PINS REFERENCE: EN020026

Written representation for Submission Reference [REDACTED]

- 1.1. This document comprises a Written Representation (WR) by myself (I/me) as an Interested Party in respect of a Development Consent Order application (“the DCO Application”) for the National Grid (“NG”) Sea Link project (“Sea Link”).

THE NATIONAL GRID (SEA LINK) ORDER  
 PINS APPLICATION NUMBER: EN020026  
 TREES AND HEDGEROWS TO BE REMOVED  
 OR MANAGED PLANS - KENT  
 REGULATION 5(2)(o)  
 KEY PLAN 1 OF 1

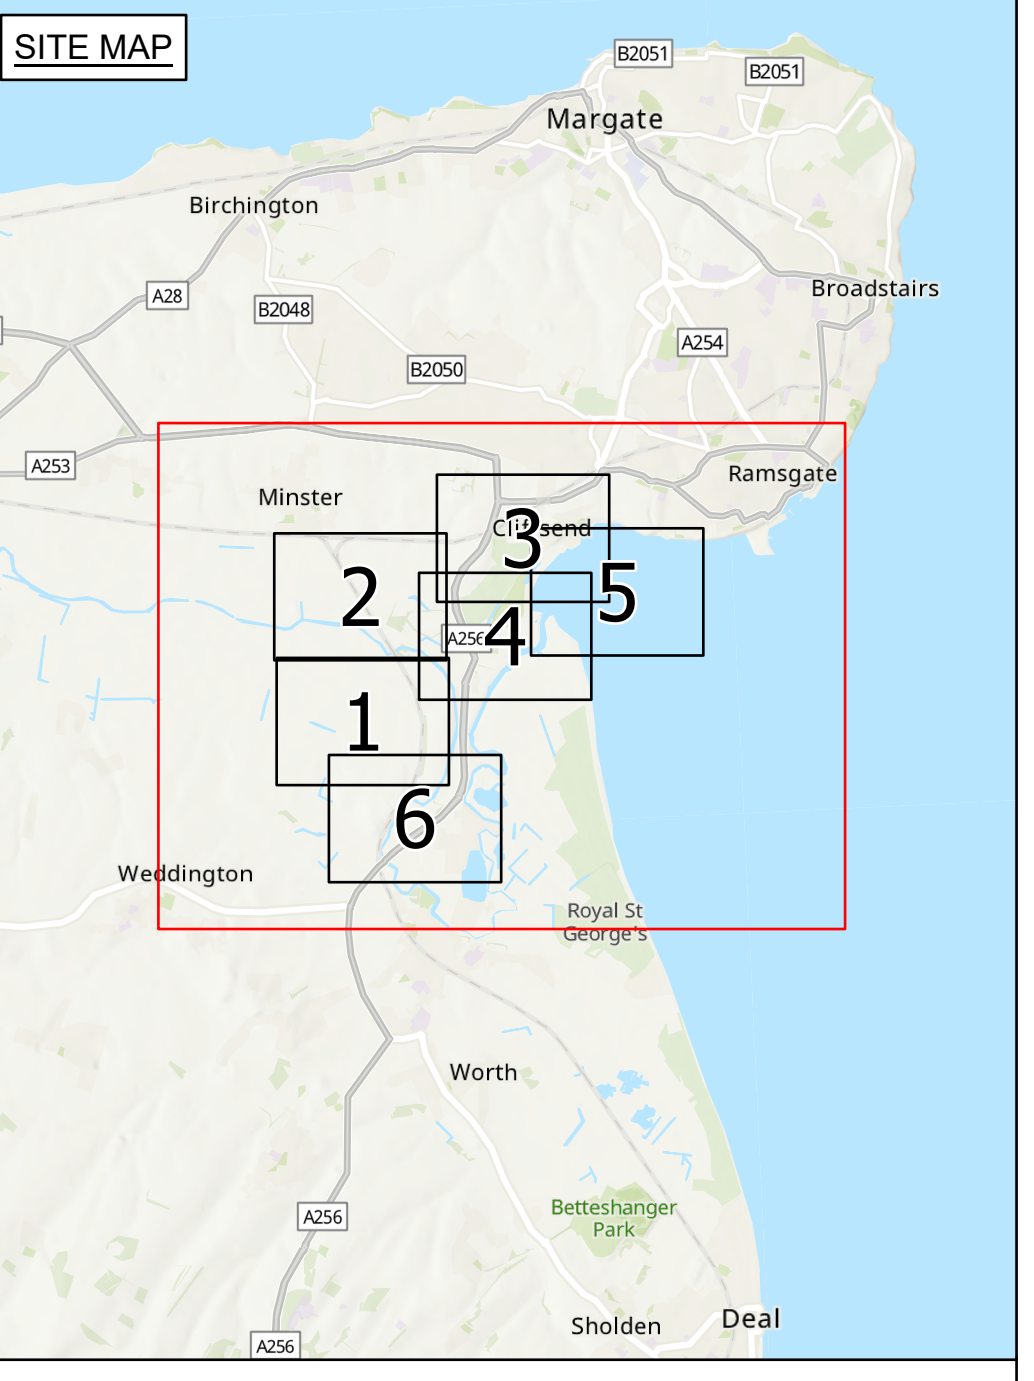
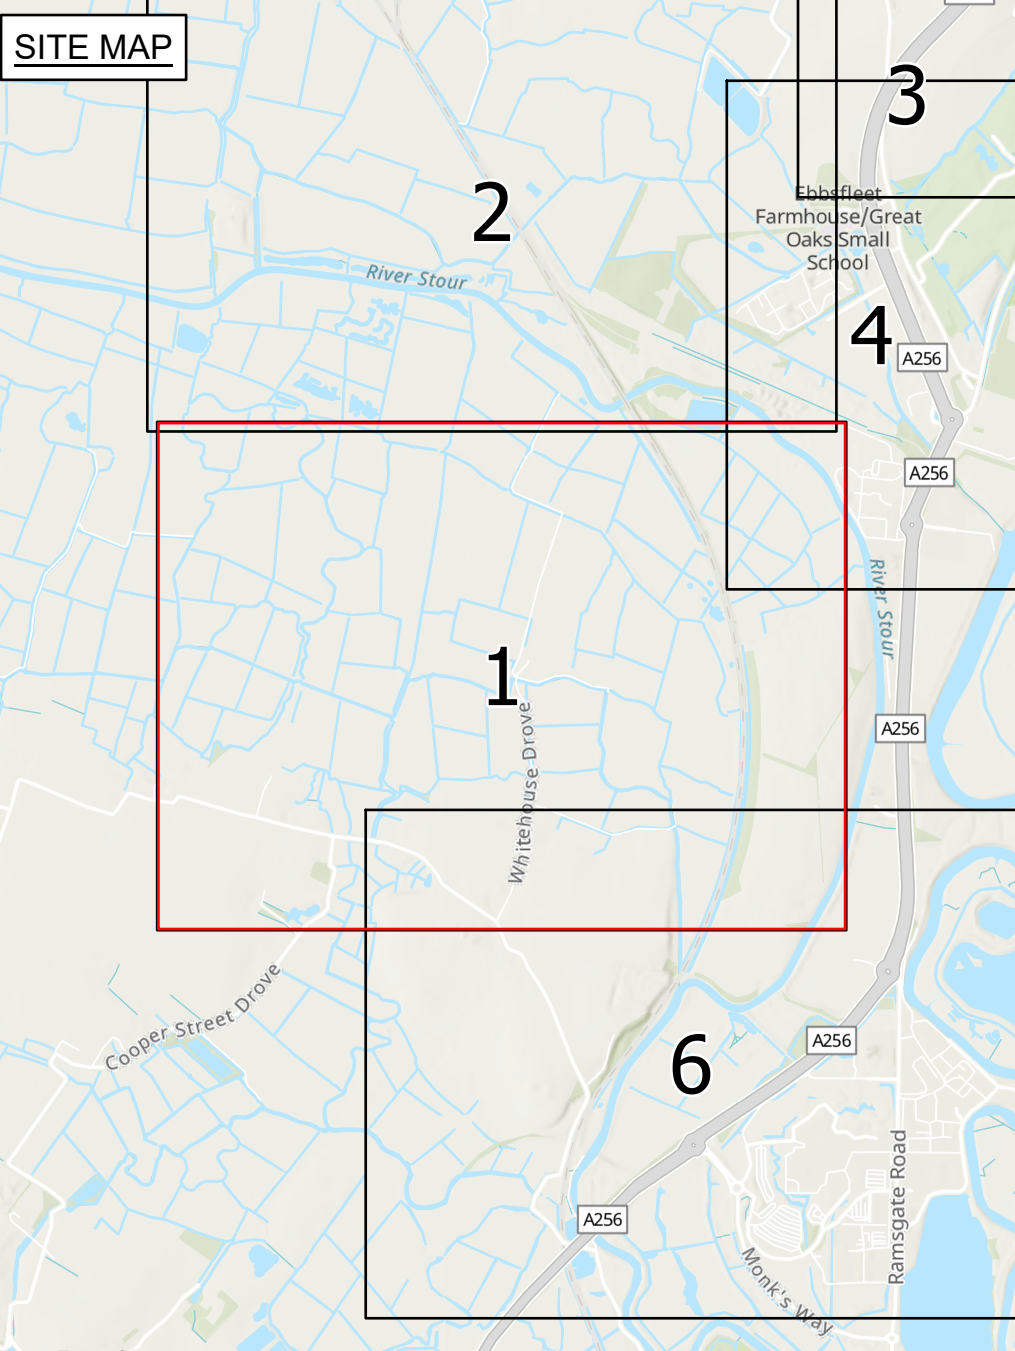
- 6.11. It appears also that a substantial section of the SSSI is to be claimed within the Draft Order Limits and is not correctly shown as Broad Leaf Woodland, see page 15 of APP – 036 2.12. Trees and Important Hedgerows to be Removed or Managed. This is only apparent on this map, is not discussed and is not shown in relation to the SSSI. This is totally unacceptable. See further discussion in the Trees and Hedgerows section.
